CITY OF ALBUQUERQUE

Re: Monterey Place Apartments
2306-2320 Central Avenue SW
Traffic Circulation Layout
Engineer's/Architect's Stamp 02-11-20

Based upon the information provided in your submittal received 02-13-20, the above referenced plan cannot be approved for Building Permit until the following comments are addressed:

TRAFFIC CIRCULATION LAYOUT

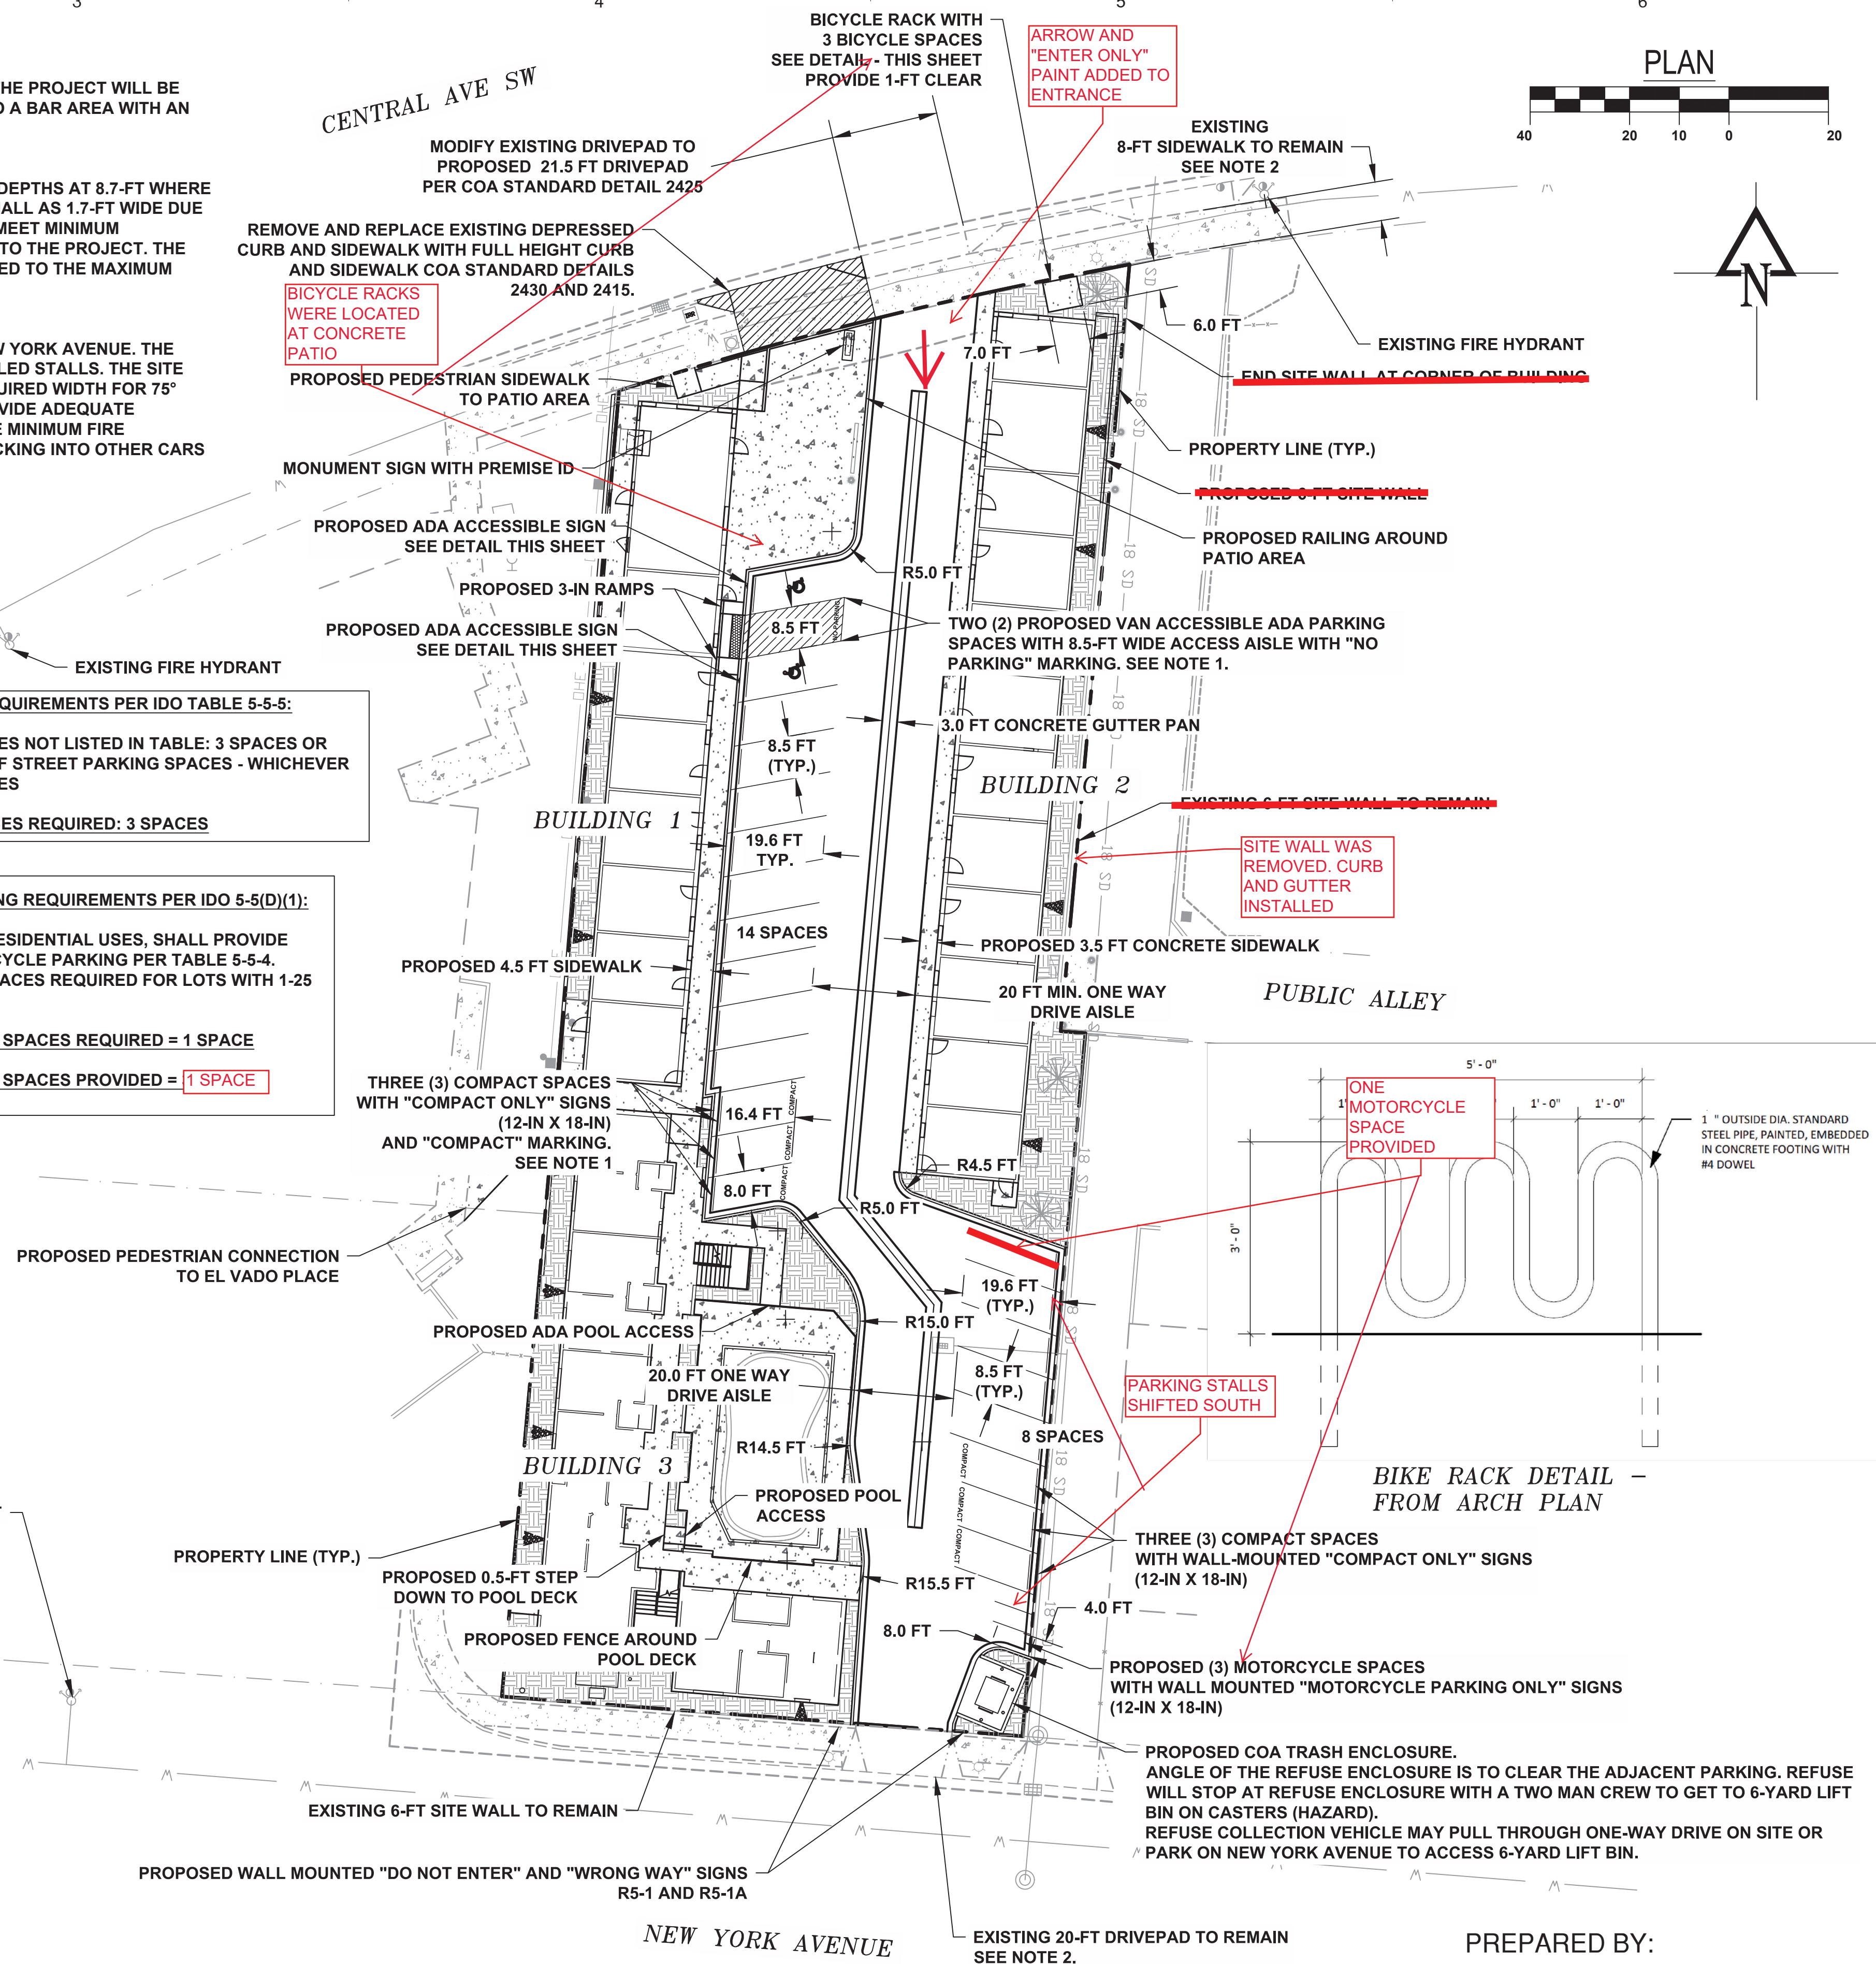
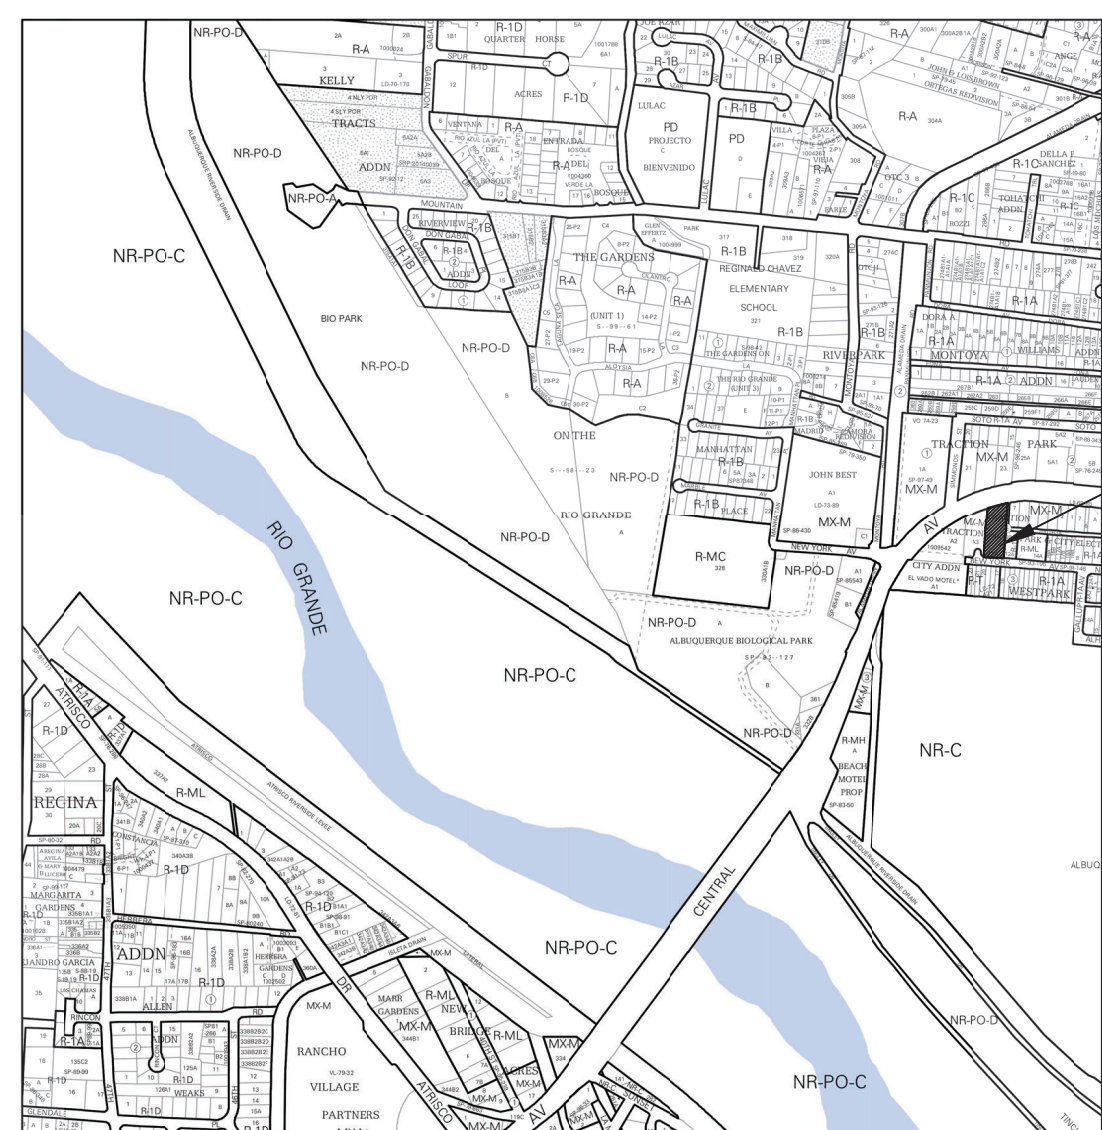
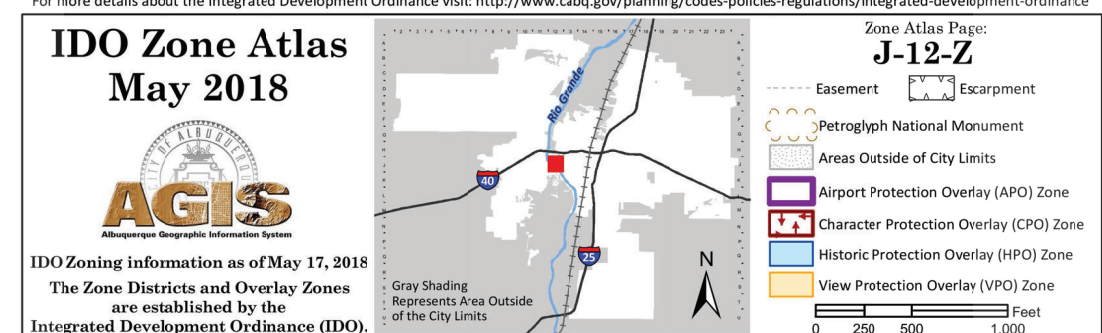
1. Please show a vicinity map showing the location of the development in relation to streets and well known landmarks.
2. Label any existing or proposed easements within the proposed development and access aisles.
3. Proposed number of parking spaces including bicycle and motorcycle parking need to be coordinated with Zoning to ensure compliance.
4. Please list the width and length for all proposed parking spaces. Some dimensions are not shown and provide landscaping buffer between curbing and sidewalk.
5. All proposed/existing entrance widths need to be shown on plans.
6. The minimum parking stall dimensions are:

7. The ADA accessible spaces must include an access aisle. Van accessible aisles should be 8ft wide; all others should be 5ft wide.

8. The ADA accessible parking sign must have the required language per 66-7-352.4C NMSA 1978 **"Violators Are Subject to a Fine and/or Towing."** Please call out detail and location of signs.

9. The ADA access aisles shall have the words **"NO PARKING"** in capital letters, each of which shall be at least one foot high and at least two inches wide, placed at the rear of the parking space so as to be close to where an adjacent vehicle's rear tire would be placed. (66-1-4.1.B NMSA 1978).

10. The sidewalk width abutting the ADA ramp transitions must be the same of the sidewalk to avoid any hazard problems.
11. Provide ADA curb ramps detail which must be the updated to current standards.

12. A detail of the water feature with ADA access crossings needs to be provided.
13. Motorcycle parking spaces shall be designated by its own conspicuously posted upright sign, either free-standing or wall mounted per the zoning code. Label MC on pavement of each space.

15. Bicycle racks shall be sturdy and anchored to a concrete pad. Show location of the bicycle racks.
16. A 1-foot clear zone around the bicycle parking stall shall be provided.

17. Bicycle parking spaces shall be at least 6 feet long and 2 feet wide.
18. Per the IDO, a 6 ft. wide ADA accessible pedestrian pathway is required from the public sidewalk to the building entrances. Please clearly show this pathway and provide details.

19. Per DPM, a 6 ft. wide ADA accessible pedestrian pathway is required from the ADA parking stall access aisles to the building entrances. Please clearly show this pathway and provide details.

20. Provide 8 ft. wide sidewalk when stalls are overhanging sidewalk. A solution would be to show parking bumpers on the south side parking stall.
